Objection to Planning Application

158 Hawthorne Way, Shelley, Huddersfield, HD8 8PX

Application: Change of use of garage to treatment room for hairdressing, including installation of bi-fold doors (Agent ref: 383-26-R1)

Council application reference: 2026/62/91926/E

PROPOSED MATERIALS	
• DOORS	— ALUMINIUM BI-FOLDS

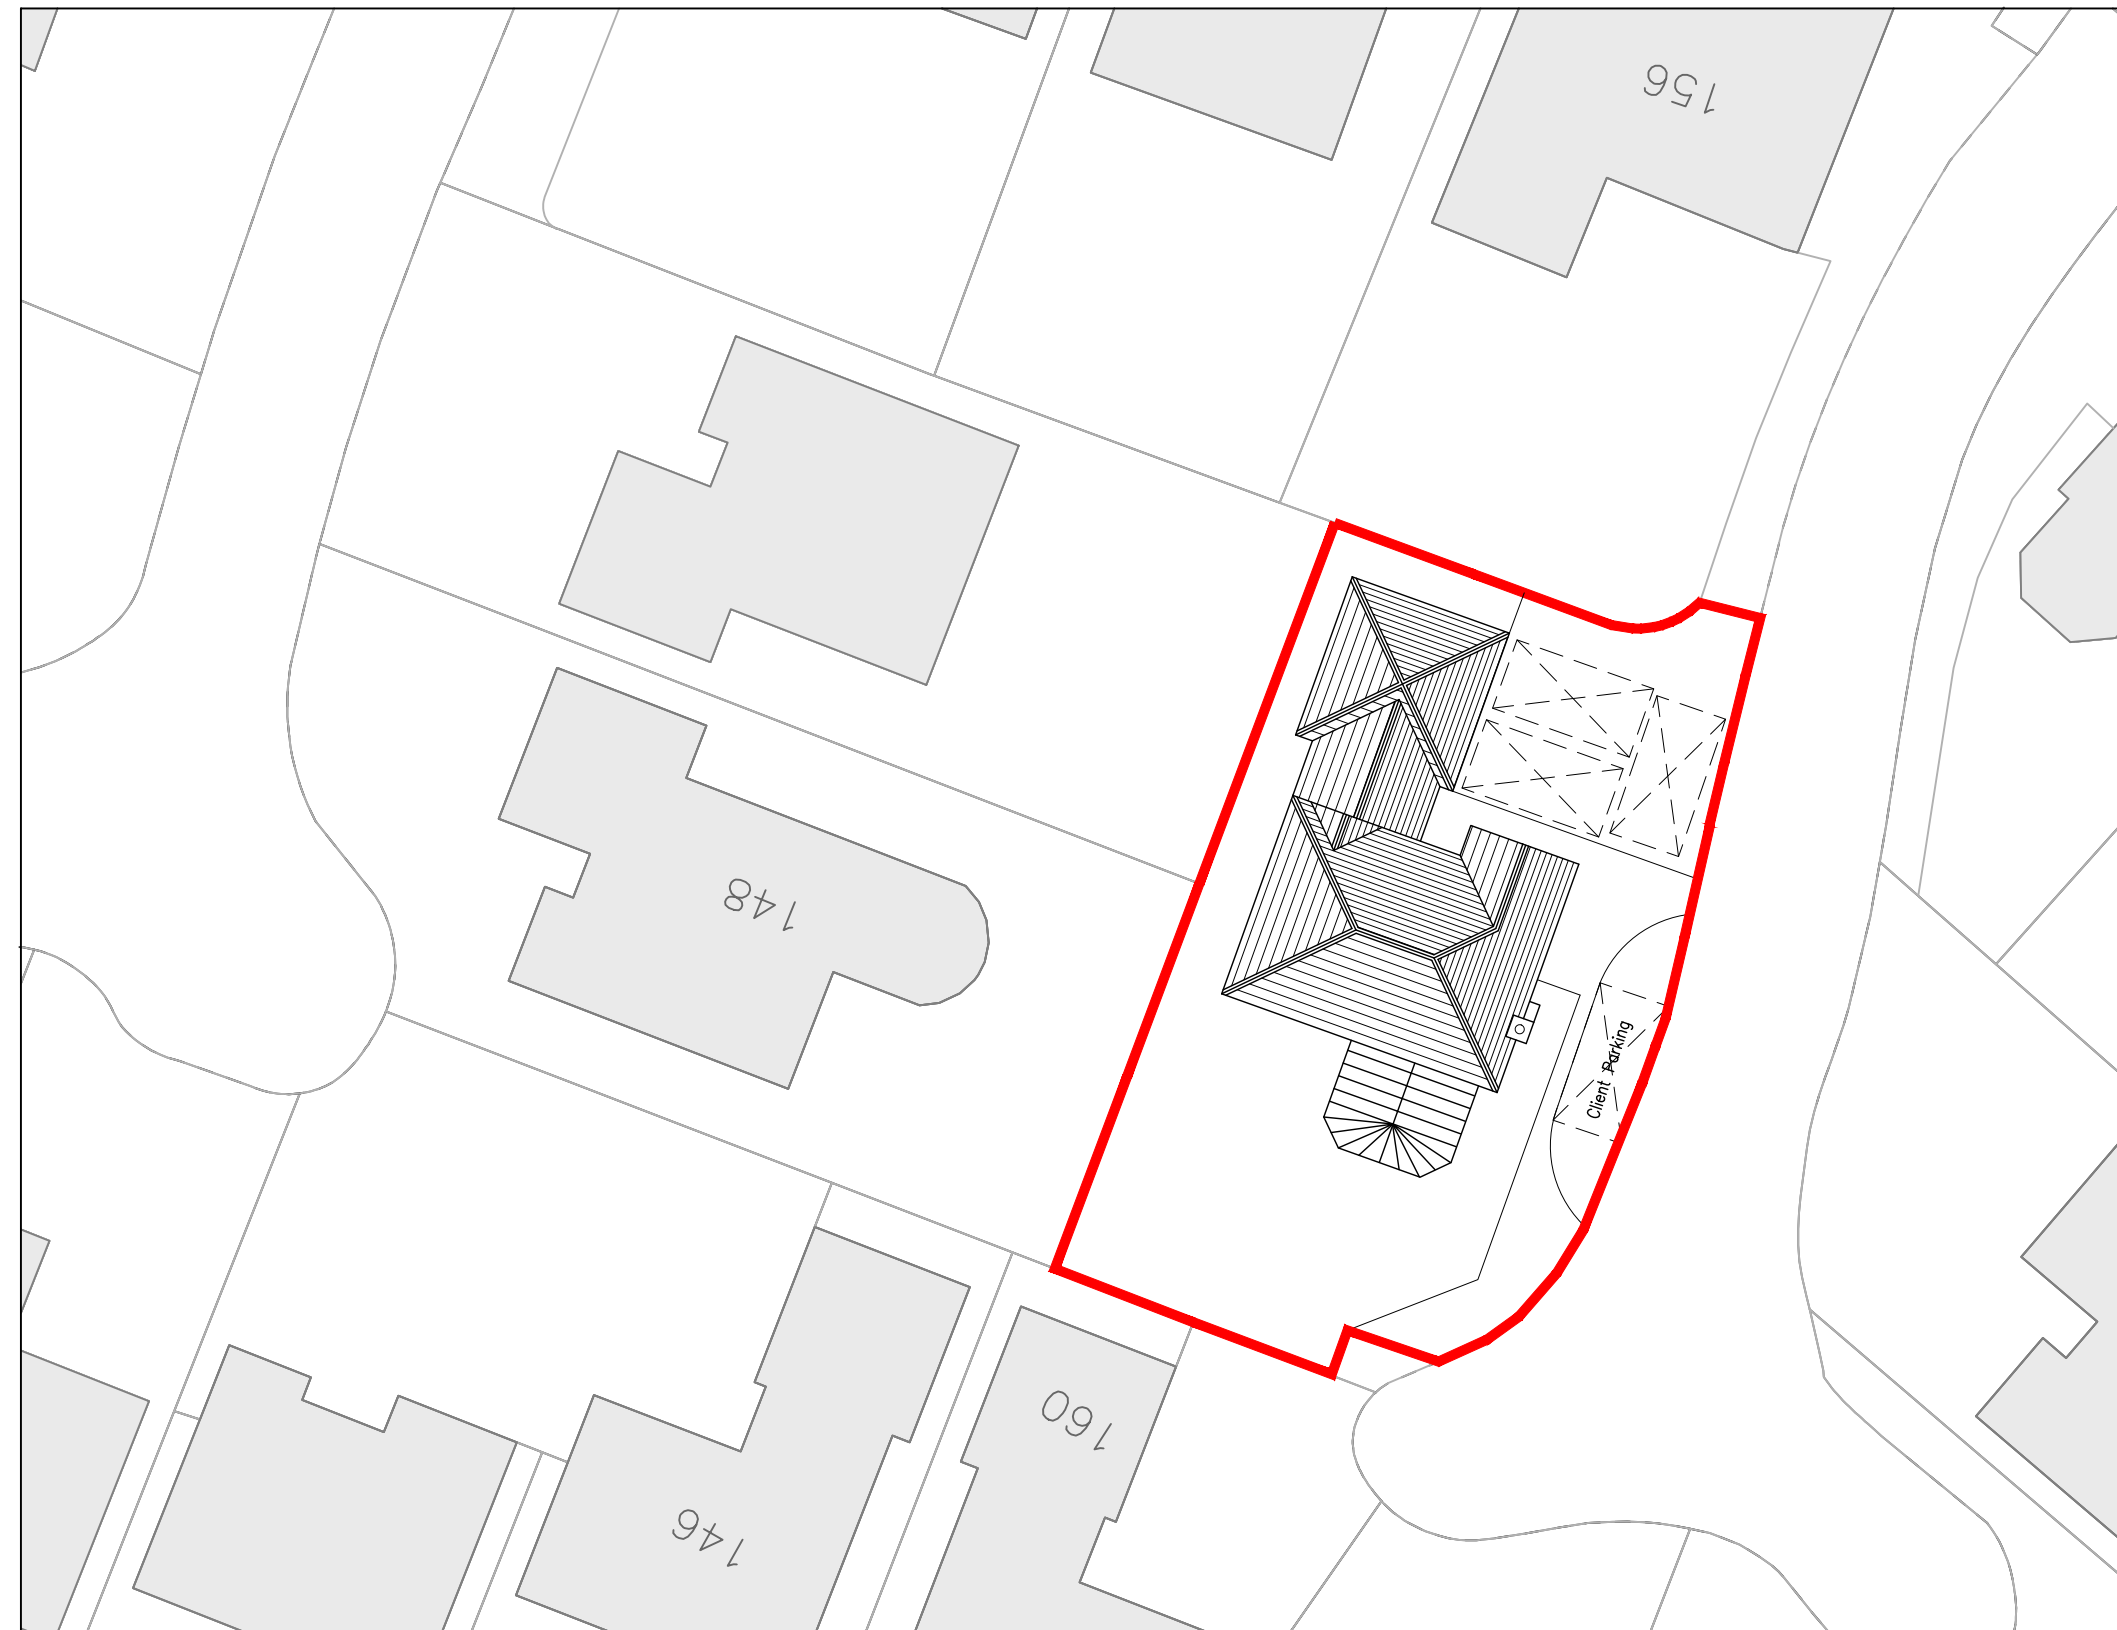
- I would further draw the Council's attention to the fact that the site plan submitted with the application is **misleading as to the extent of the driveway**. The concrete divider line that originally separated the driveway from the protected service strip was removed by a previous owner, who tarmacked the drive and service strip over as one continuous surface, contrary to the restrictions applying to the strip. The application drawings present this enlarged tarmacked area as though it were all legitimate driveway, when in fact part of it is the service strip which should never have been surfaced over. The plans therefore do not accurately reflect the lawful extent of the parking area, and the Council should not rely on them when assessing the parking provision.

- The submitted plans show three parking spaces on the drive, with two positioned up to the property boundary. This takes no account of the clearance needed to **open the proposed bi-fold doors**, which are likely to require in the order of a metre of space and if access to the business is through those doors, a clear gap would be required at all times. In practice there is not space for three cars on the drive: the third vehicle would have to sit partly across the bottom of the drive and partly on the road, obstructing the neighbour opposite when reversing into or out of their own drive.

- Full-height glazed bi-fold doors facing the street are a feature of **commercial premises, not domestic garages**. On a residential estate of traditional design, this alteration would read unmistakably as a **shop front**, visually announcing a commercial operation at the heart of a residential cul-de-sac.

- The application itself confirms this commercial character: the doors are to incorporate “integrated blinds to maintain privacy **during operational hours**” — language that describes retail premises, not a dwelling.

- The design is entirely out of keeping with the character and appearance of the street scene, where properties present traditional garage doors and domestic frontages. No other property on the estate has anything resembling a glazed commercial frontage.

- There is an established local precedent for how garage conversions should be handled on this estate: at **168 Hawthorne Way**, the garage door was replaced with brickwork and two windows, in keeping with the domestic character of the street. If any conversion were to be permitted here, that is the appropriate treatment — not a full-width glazed opening.
